Our Ref: ID 1623  
Your Ref: SSD-23512960

**Request for advice on the Glenwood High School Flood Emergency Management Plan (FEMP)**

Thank you for providing NSW State Emergency Service (NSW SES) the Flood Assessment and a Flood Emergency Management Plan (FEMP) for the proposed development at Glenwood High School.

Figure 7: Proposed Emergency Assembly Area and Evacuation Route

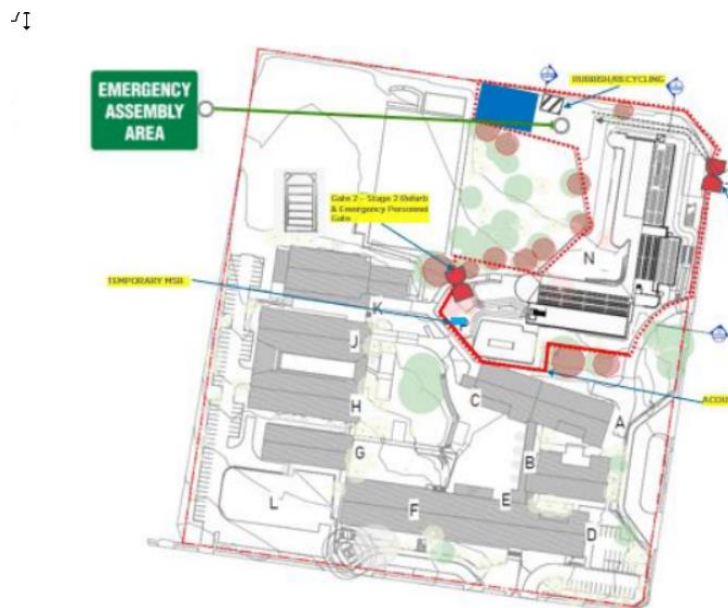
- **Development strategies relying on deliberate isolation or sheltering in buildings surrounded by flood water are not equivalent, in risk management terms, to evacuation.** Sheltering in a building within the flood extent is not safe, as proposed in section 7 of the FEMP. Sheltering in buildings where entrances and exits may become flooded in the larger floods may result in isolating the children potentially without food or water for several hours or more depending on the weather system/s. Isolation also increases the risk of fire or medical emergencies and likelihood of caregivers entering floodwater to get to their children. It is unrealistic to assume parents or caregivers will not attend the school to pick up children in circumstances of flooding.

Section 7 of the FEMP should be reworded to clarify that the primary strategy is ensuring early closure of the school, for instance based on a severe weather warning for flash flooding or as there is no flood warning system and there is likely to be rapid rises, on the first sign of flooding. This would allow additional time for caregivers to pick up the children.

A contingency plan would be to walk out of the area at risk of flooding along pathways. Design of the new school buildings should also ensure an elevated walkway to the remainder of the school from the upper levels of the buildings. There would therefore be no need to shelter in place.

In summary, the preferred emergency strategy for the school is early closure prior to the commencement of flooding and before the start of the school day. As a contingency, at the first sign of flooding, people located in the north-eastern part of the school should relocate to an area that is not at risk of flooding.
